CITY OF ALBUQUERQUE

May 24, 2024

**RE: Cactus Patch Plaza
7801 La Morada Place NW
Grading and Drainage Plan
Engineer's Stamp Date: 05/14/24
Hydrology File: H10D034**

**RE: Cactus Patch Plaza
7801 La Morada Place NW
Grading and Drainage Plan
Engineer's Stamp Date: No Date
Hydrology File: H10D034**

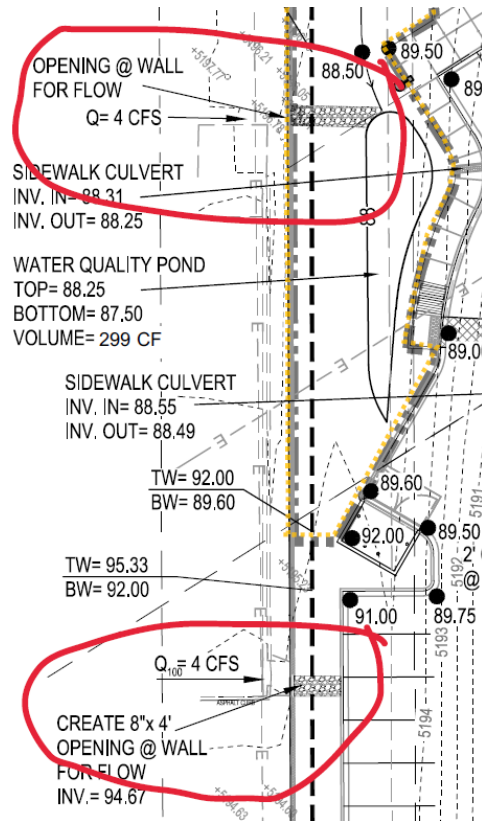
3. Please provide a curb cuts for the offsite flows (4 cfs).

added private
storm drain with
inlets at each
concentration and
overflows

← ADDED

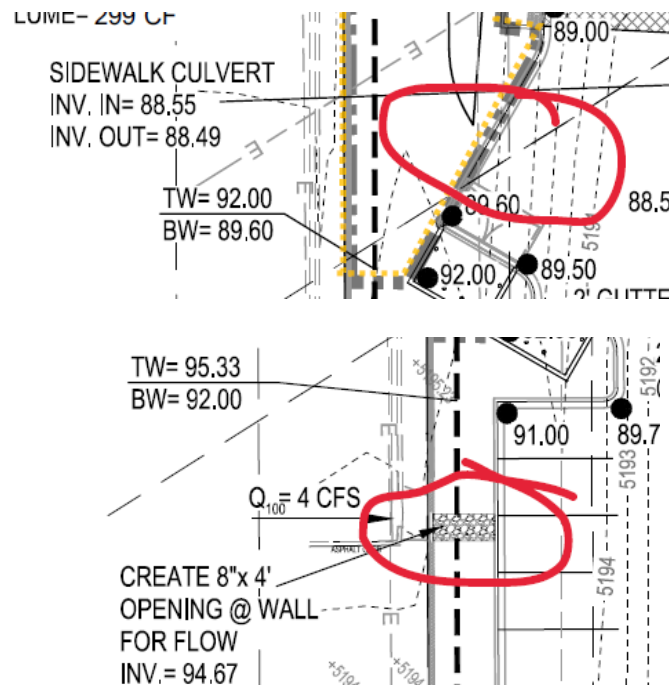
- How does this drainage area get into the provided stormwater quality pond? It appears that this entire paved parking and access road does not drain into a pond.

LOWERED THIS
SPOT TO
CAPTURE FLOW

THIS INLET
CAPTURES THE
FIRST FLUSH
